14 October 2021

Our Ref:
LY/APC/1812/20211014

**Re: Application in respect of land at Woodgate Centre, Oak Tree Lane, Woodgate
PO203GU (Application Reference AL/107/21/PL)**

5.3 PROPOSED MATERIALS LAYOUT

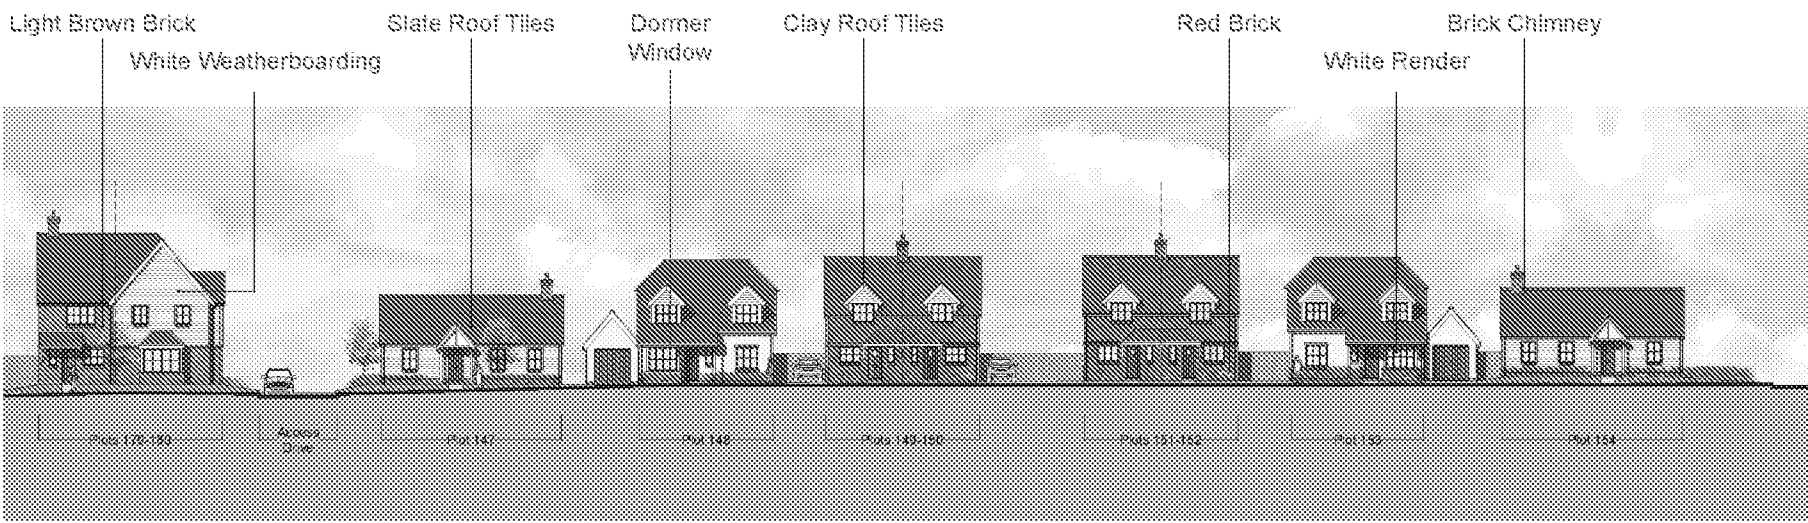
Whilst an attempt has been made to introduce elements of traditional materials, it is not clear whether the proposed weatherboarding (one of the prevailing materials of the proposal) would be natural timber or an artificial alternative. Page 108 of the Design Guide promotes the use of natural, sustainable materials wherever possible. Furthermore, weatherboarding itself is not specifically referred to within the Design Guide as one of the key materials which define the character of Arun district.

5.4 STREET SCENES

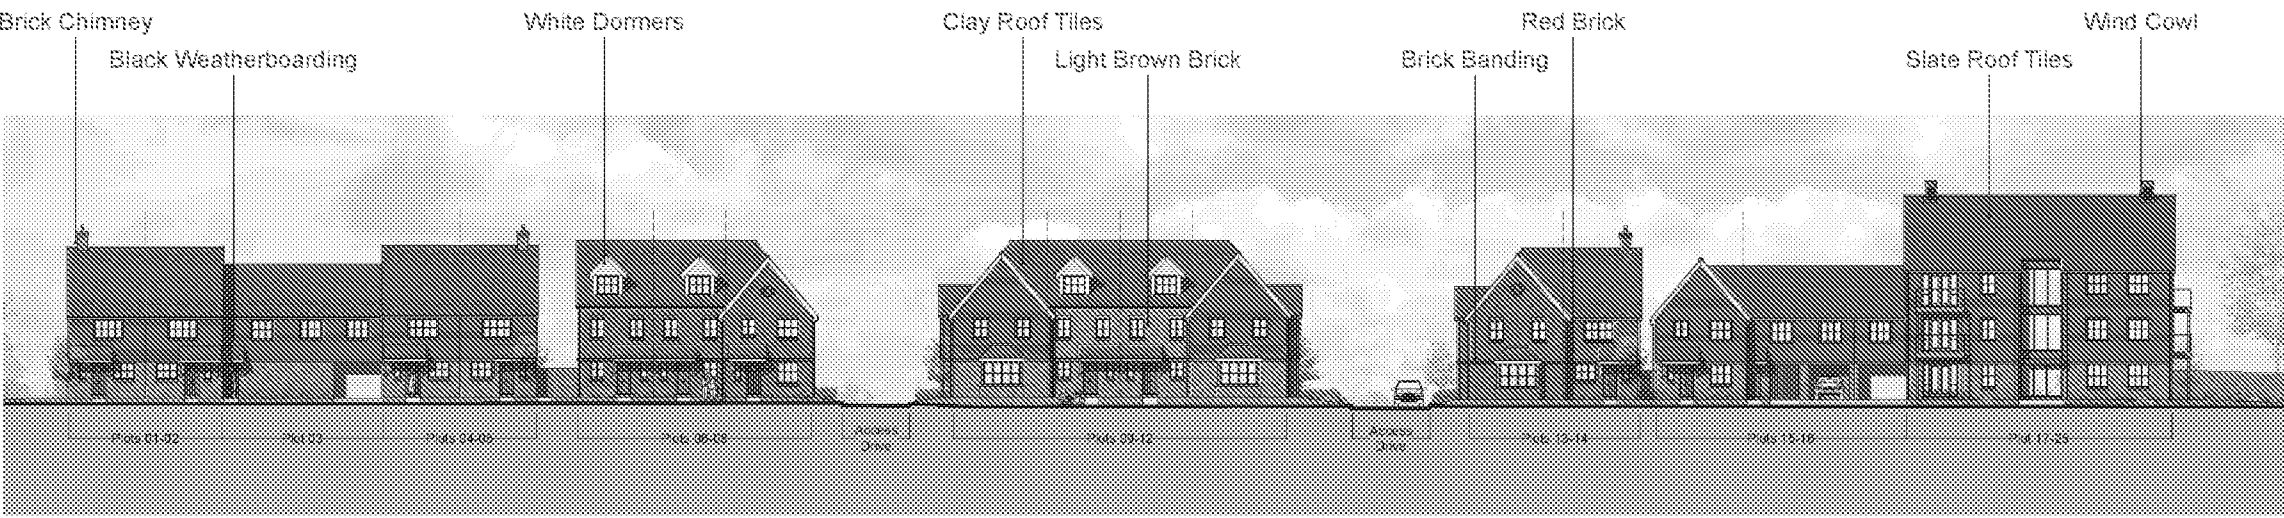
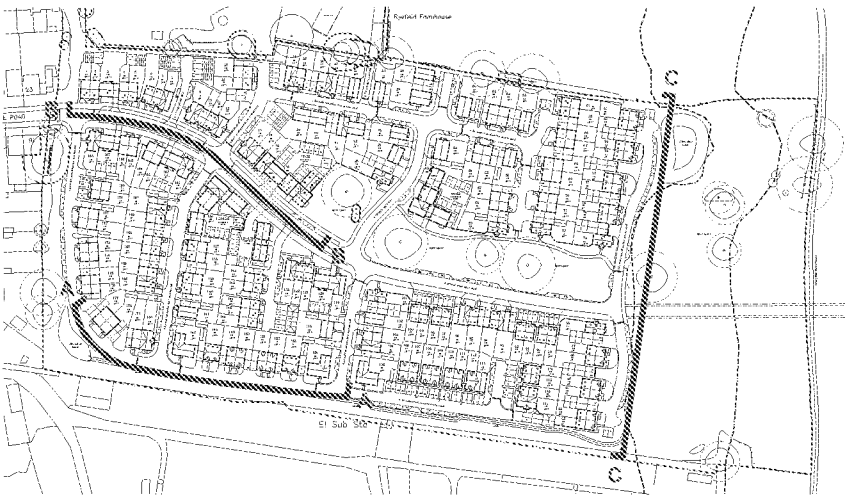
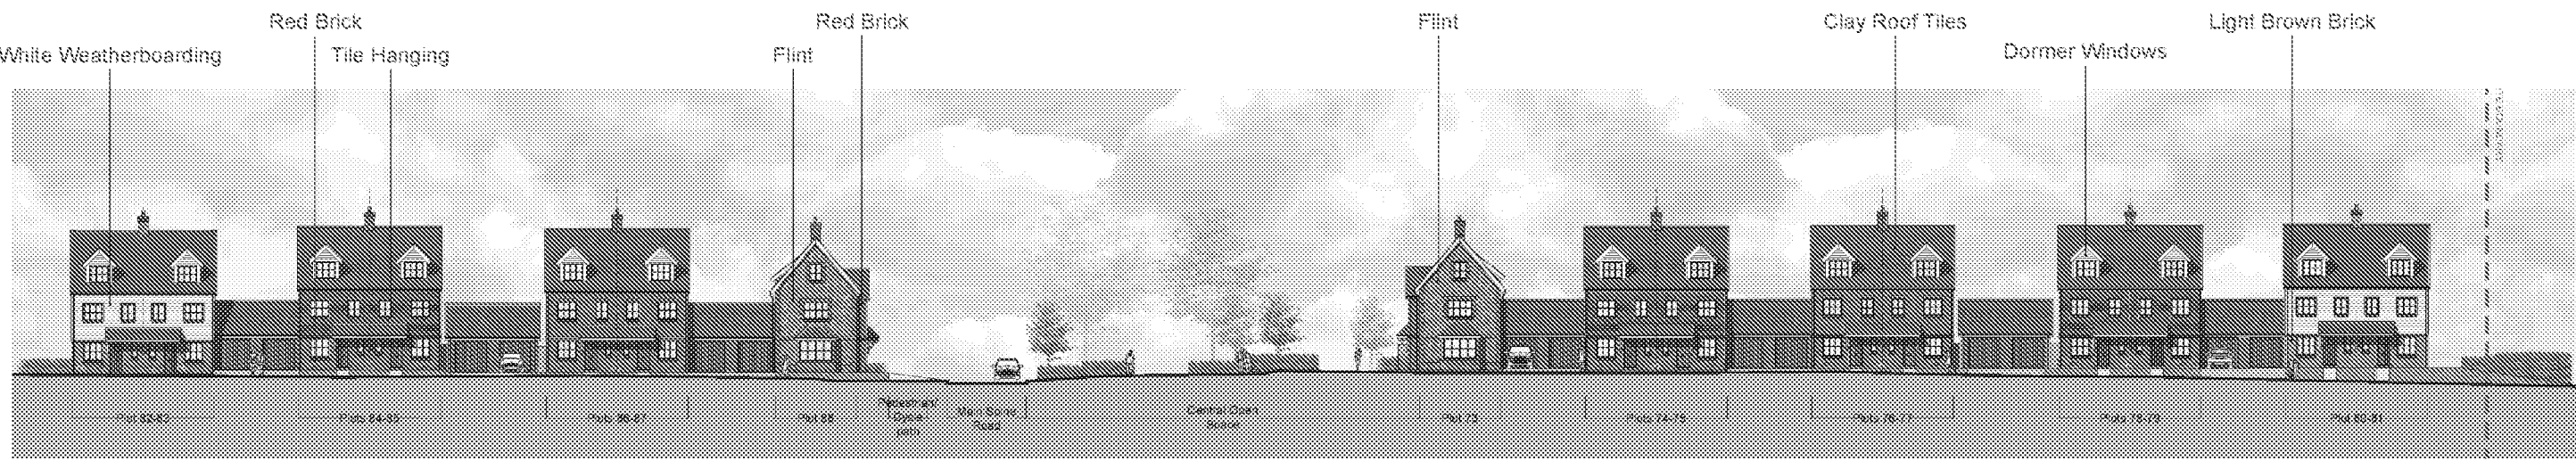
Woodgate Lane, which lies immediately adjacent to the site, predominantly comprises single storey bungalows. Whilst Oak Tree Lane has a number of 2 storey dwellings, there appears to be no significant precedent for 3 storey flats in the locality. With this in mind, the proposed 2.5 and 3 storey units would appear to be at odds with the prevailing character and scale of development in the immediate area. This would be contrary to the guidance set out on page 86 of the Design Guide which seeks to ensure the scale and massing of development responds to the existing townscape and landscape.

The majority of the proposed dwellings would have wide spans, and bulky, complex rooflines, resulting in a very top heavy, suburban form which fails to reflect the semi-rural character and identity of the locality. The very steep pitches and various blank facades which prevail throughout the development would be at odds with the guidance set out on page 90 of the Design Guide. This document recognises that the character of a settlement or place is defined by roof pitch and form to a high degree. The prevailing roof forms in the District are simple and double pitched gable ends or hipped roofs. New developments should respect such characteristics, while remaining in line with the location, context and character of development. In general, roof form should be simple and express and articulate the form of the building rather than obscure it. High pitch angles should not be used. Simplicity in roof form should not be compromised.
